Application no: **3/2021/0217**

Address: **8 Whittam Road Whalley BB7 9SB**

Proposal: **Proposed double storey rear and side extension with garage conversion, new canopy to entrance door and new widened driveway to front garden.**

The LHA have viewed the plans and highway related documents and have the following comments to make:

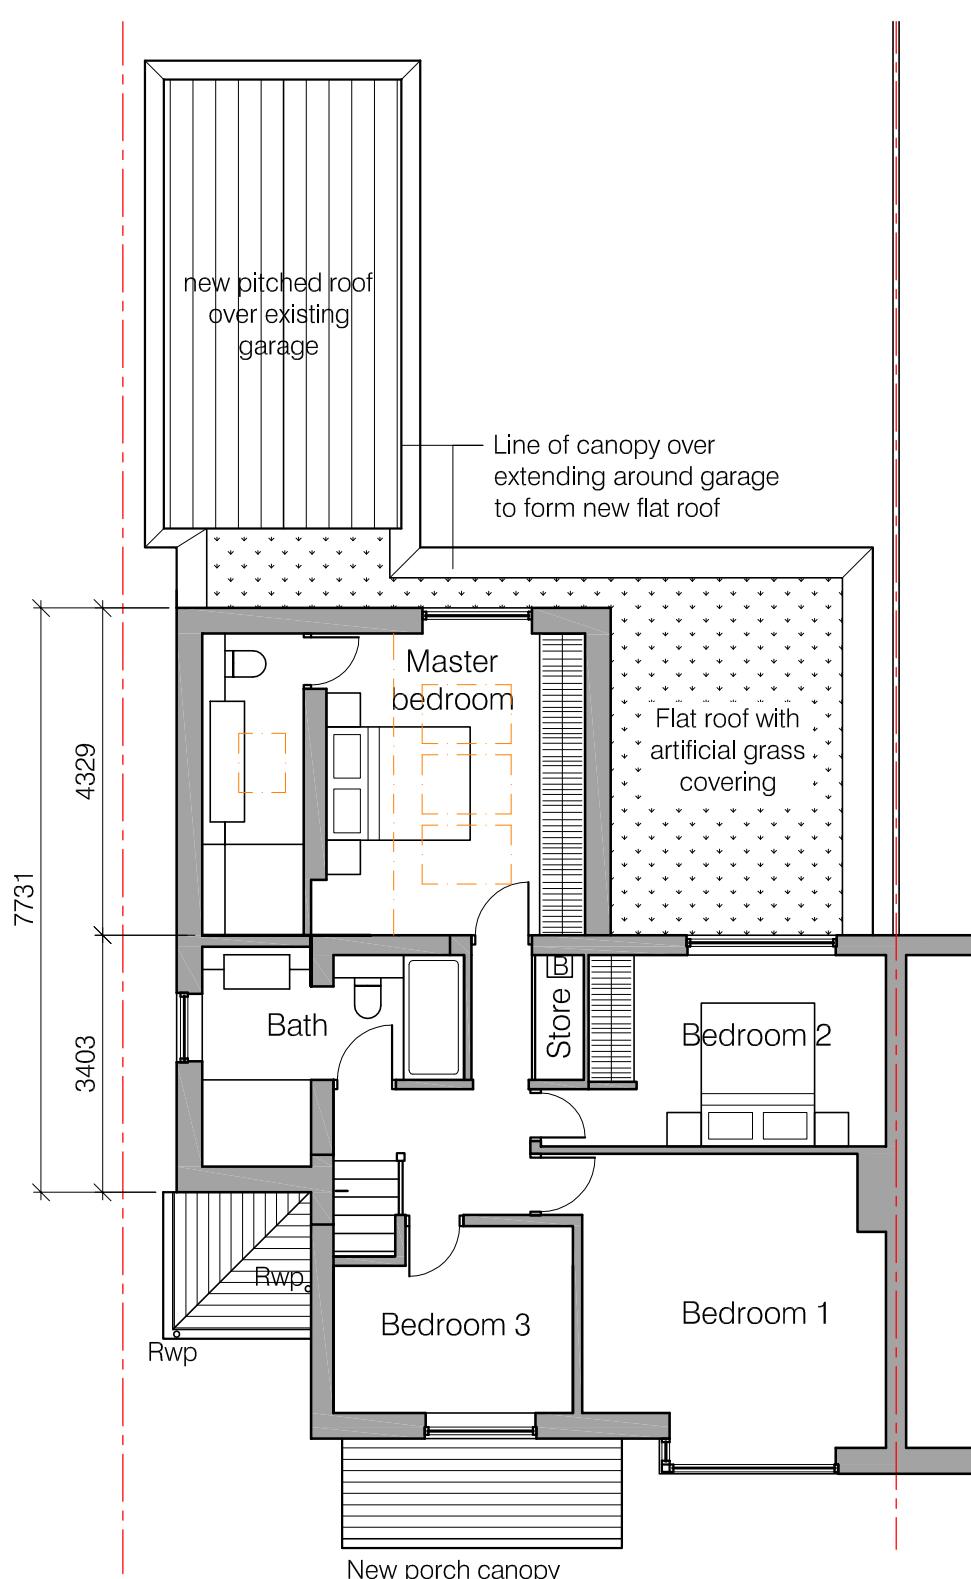
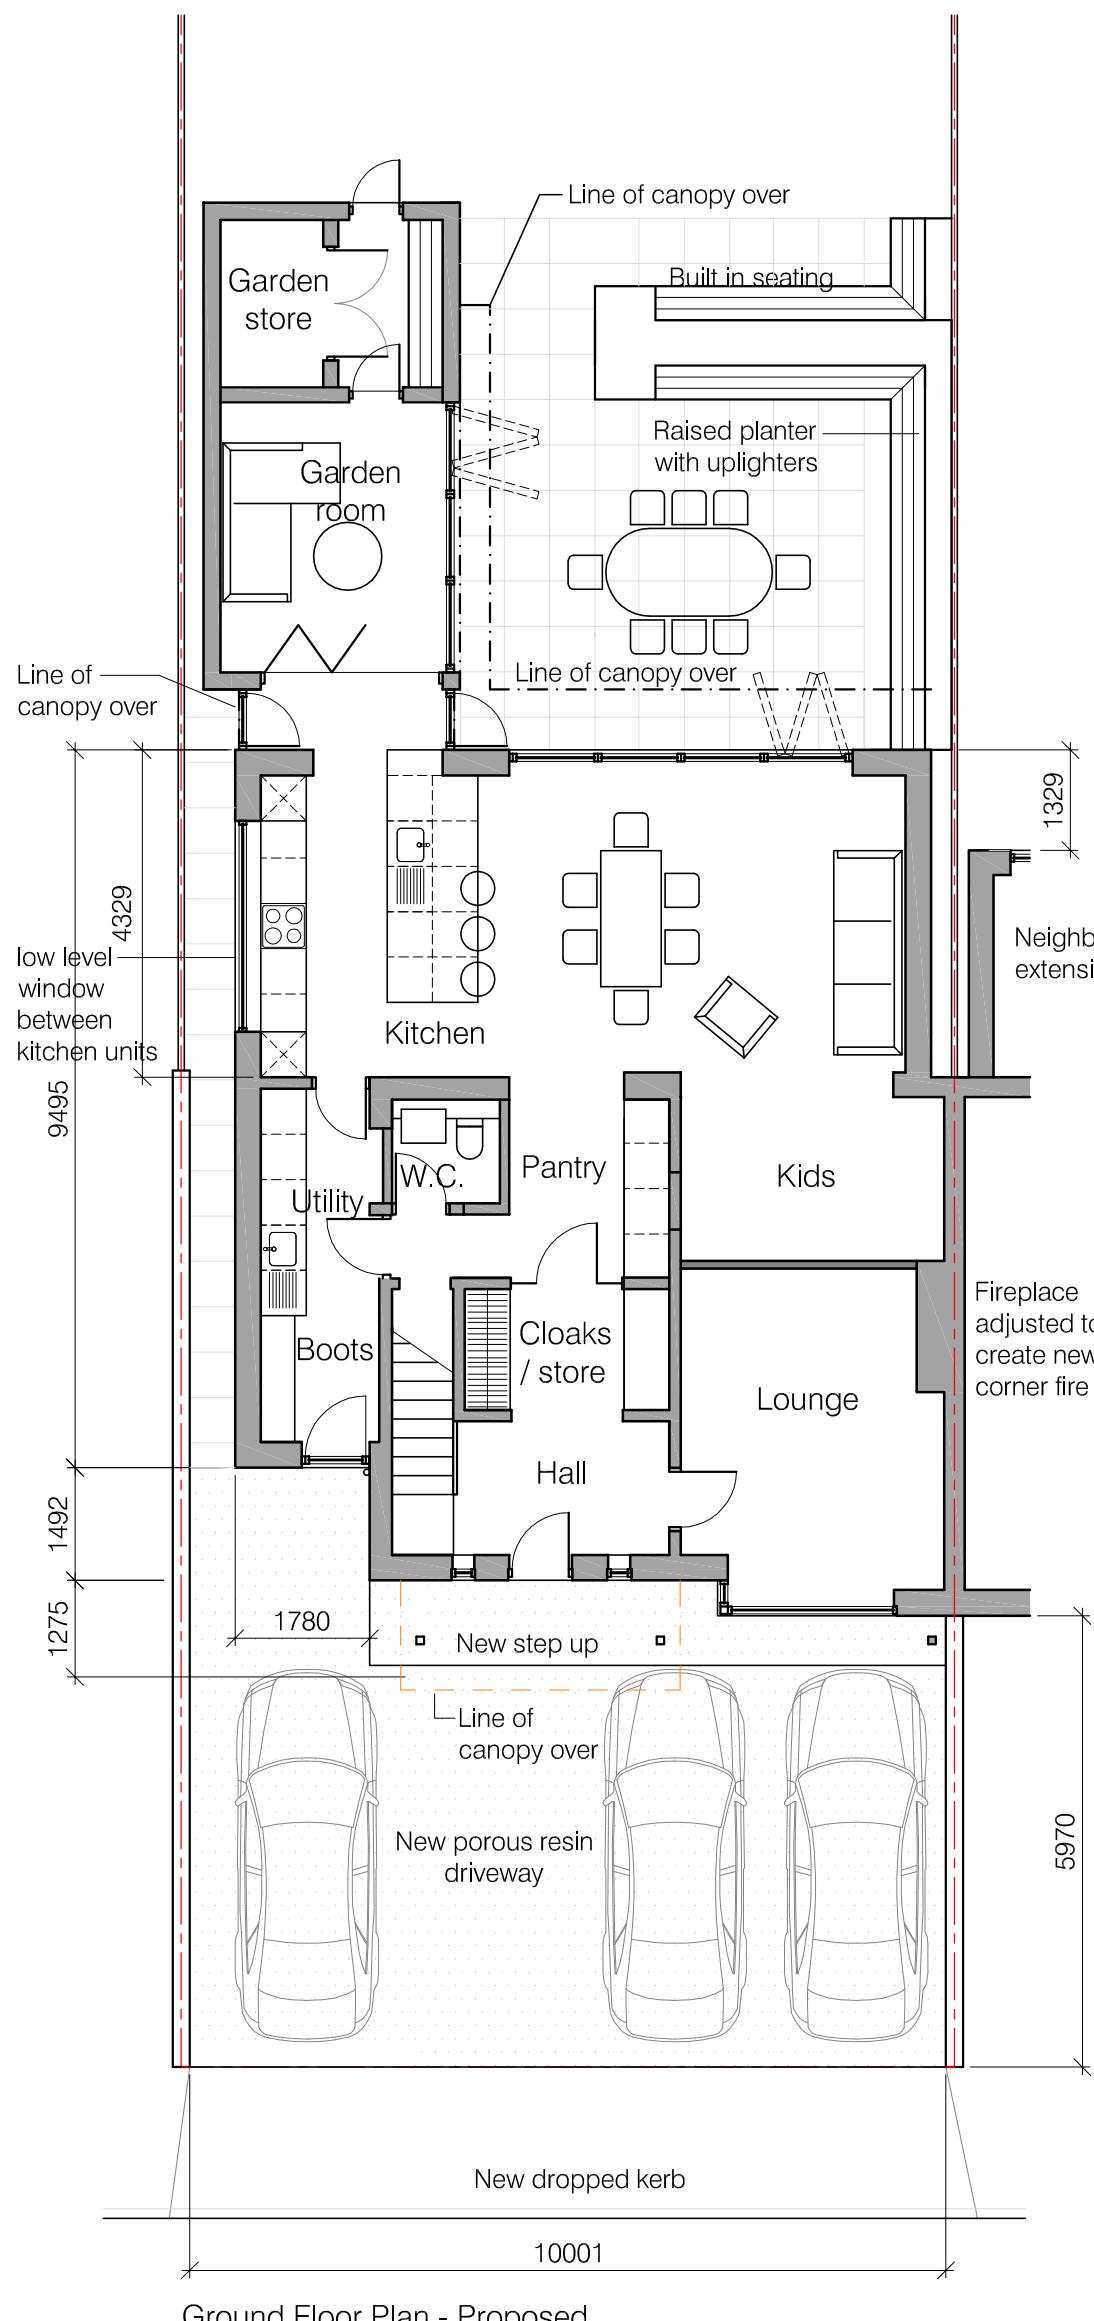
The LHA have reviewed LMC Architecture drawing number 2077-PL10 titled "Proposed Ground and First Floor Plans" which shows that the access will be served by a 10.01m dropped kerb.

The LHA have no objection to the extension to the existing dropped kerb and have no further comments to make regarding the site access.

The LHA have reviewed LMC Architecture drawing number 2077-PL10 titled "Proposed Ground and First Floor Plans" and understands the site will provide 3 car parking spaces for the 4-bed dwelling. This complies with Lancashire County Councils local guidance and therefore have no further comments to make.

1.No part of the development hereby permitted shall be occupied until such time as the access arrangements shown on LMC Architecture drawing number 2077-PL10 have been implemented in full.

2.The development hereby permitted shall not be occupied until such time as the parking and turning facilities have been implemented in accordance with LMC Architecture drawing number 2077-PL10. Thereafter the onsite parking provision shall be so maintained in perpetuity.

3.Before the access is used for vehicular purposes, that part of the access extending from the highway boundary for a minimum distance of 5m into the site shall be appropriately paved in tarmacadam, concrete, block paviours, or other approved materials.
